Comments on the Applicant's D3 Submissions

This document sets out the comments by Cambridgeshire County Council (**CCC**) on the Applicant's Deadline 3 (**D3**) submissions. The table below provides the relevant paragraph or reference numbers.

2.6 Statutory and Non-Statutory Sites or Features for Nature Conservation Plan P03 [\[REP-3-008\]](#)

APFP Reference
Regulation 5(2)(a)

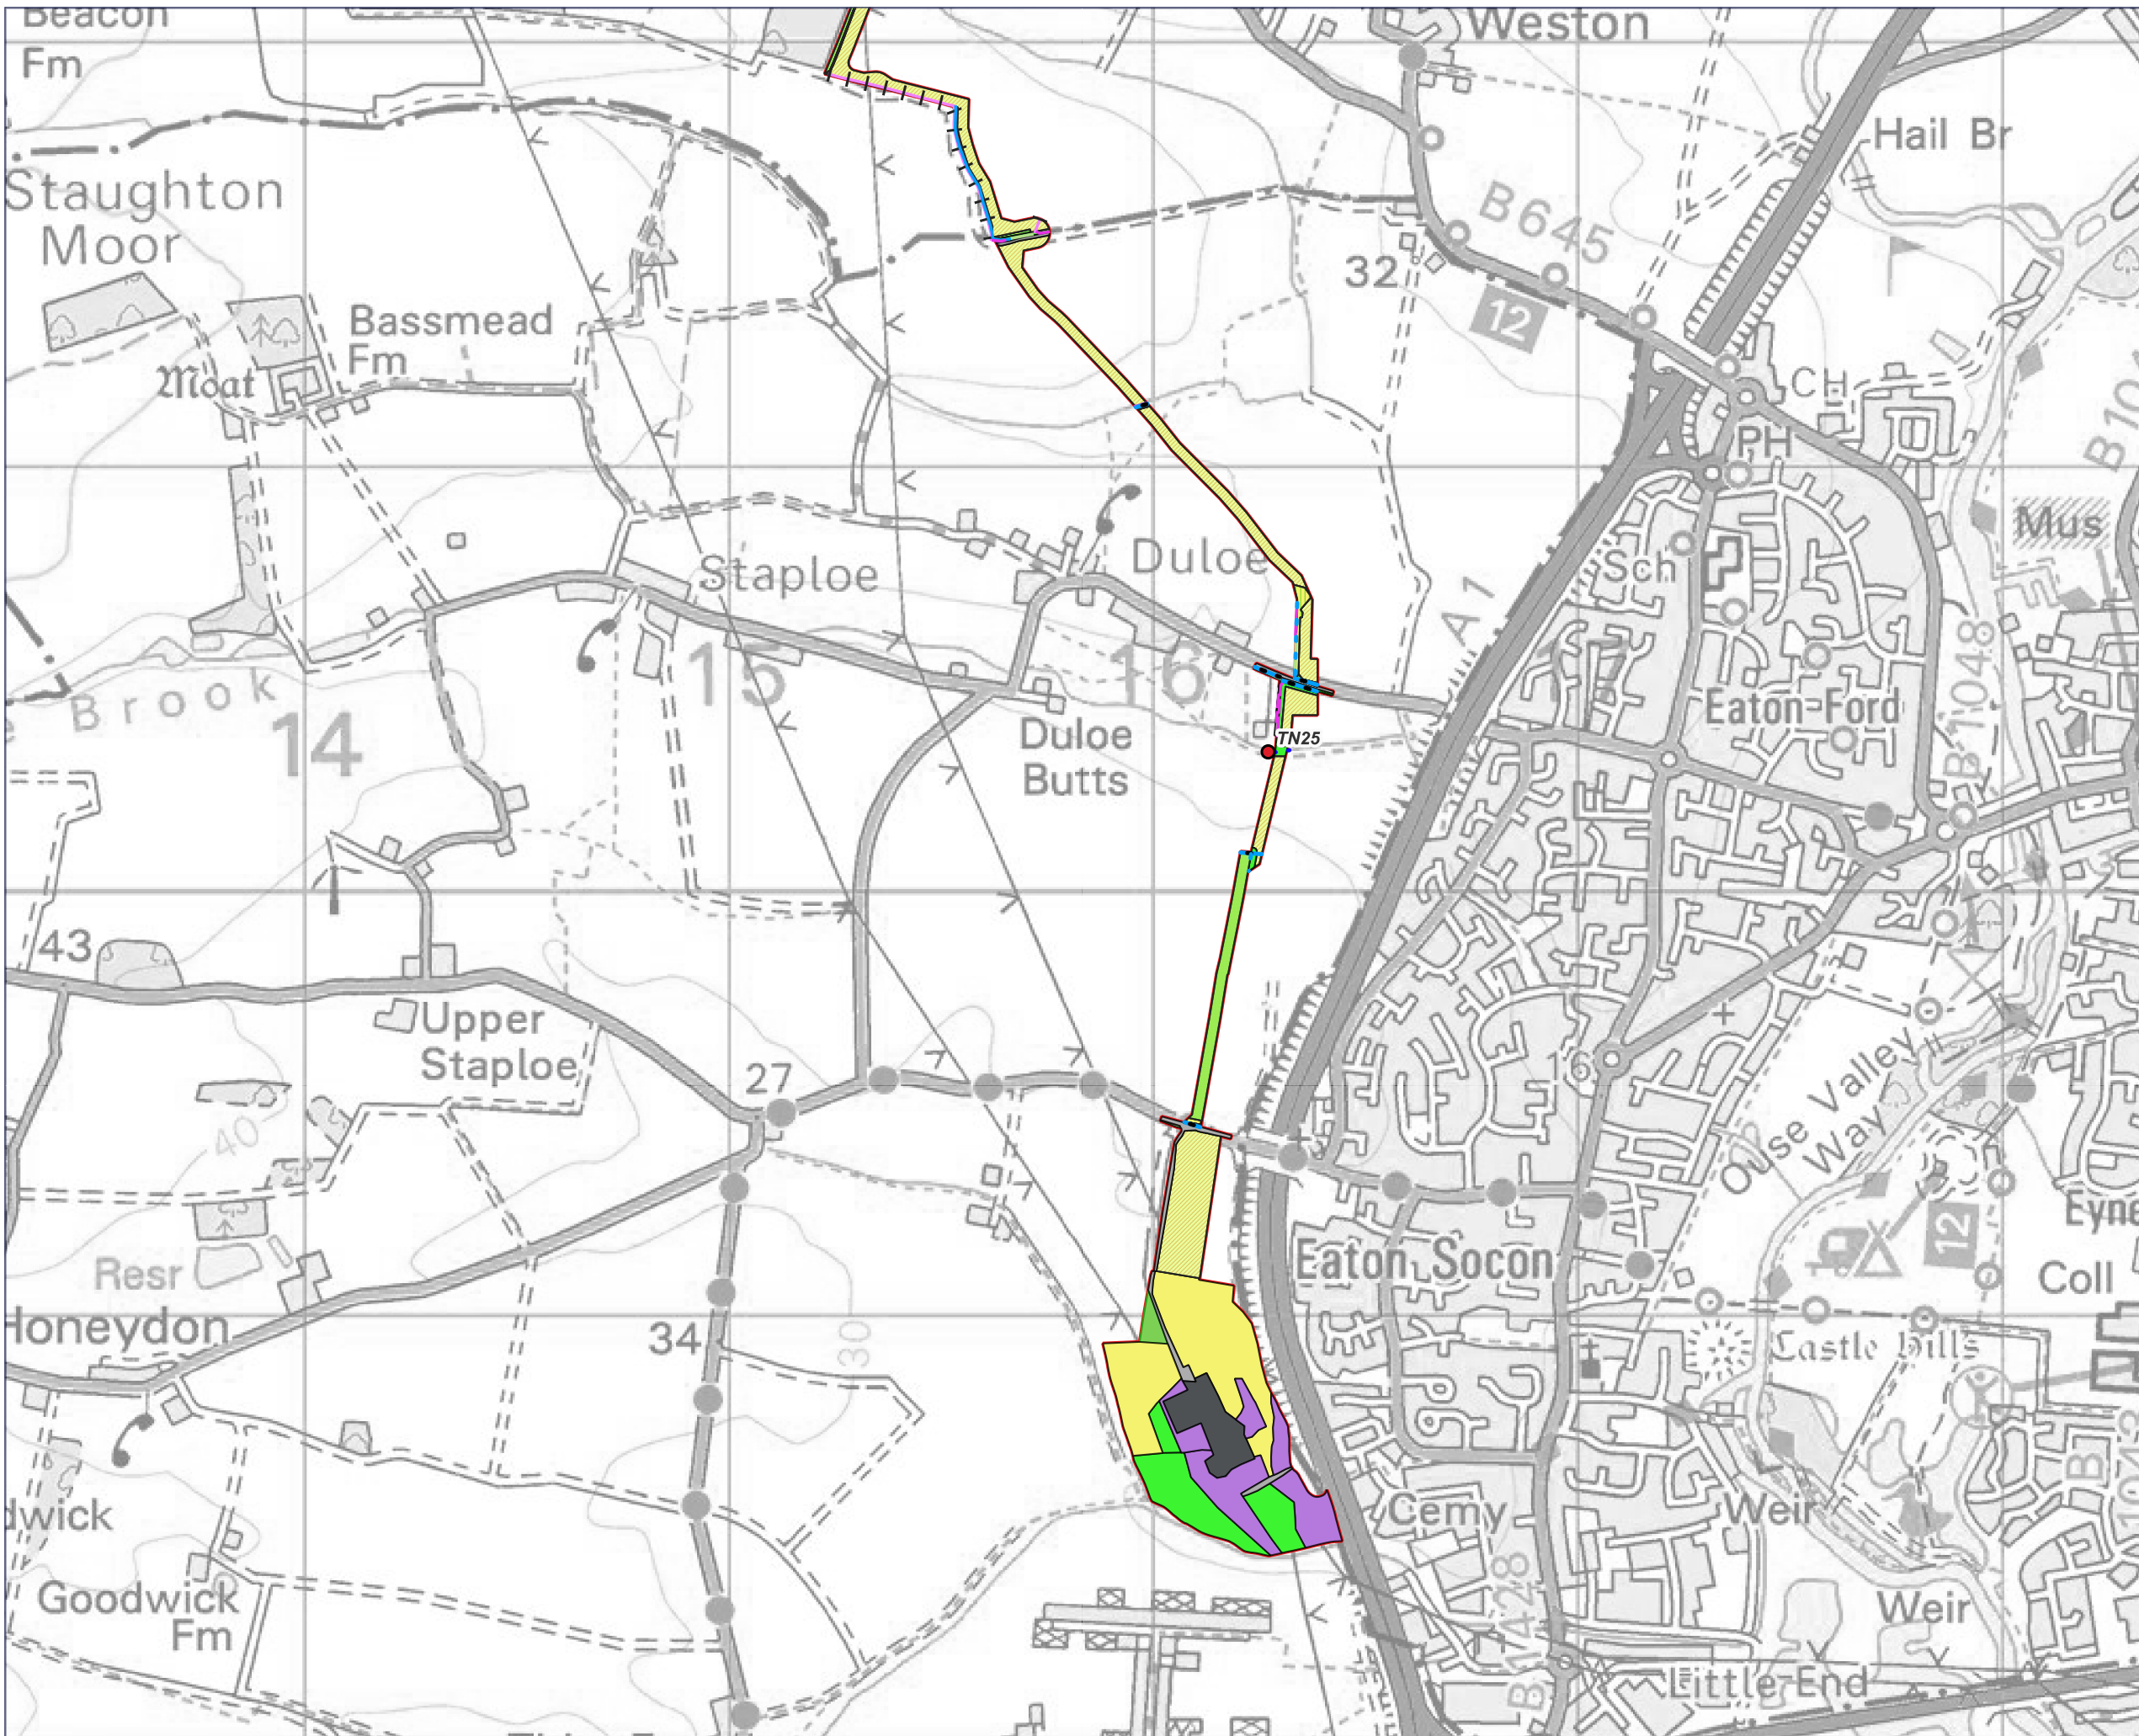
Figure 7-3	Figures 7-3a to 7-3d	No tracked changes version of the document has been provided and therefore, it is difficult to understand what has been altered, since the previous versions. The council assume that all drawings with the original version (P01) indicated on the drawings have not been changed. This suggests that only Figure 7-3 has been updated. The Council seeks confirmation as to what has changed on figures 7-3a to 7-3d
Figure 7-3 – Habitat Survey	Figures 7-3e to 7-3g	The Council welcomes clarification as to the extent of areas of limited survey access.
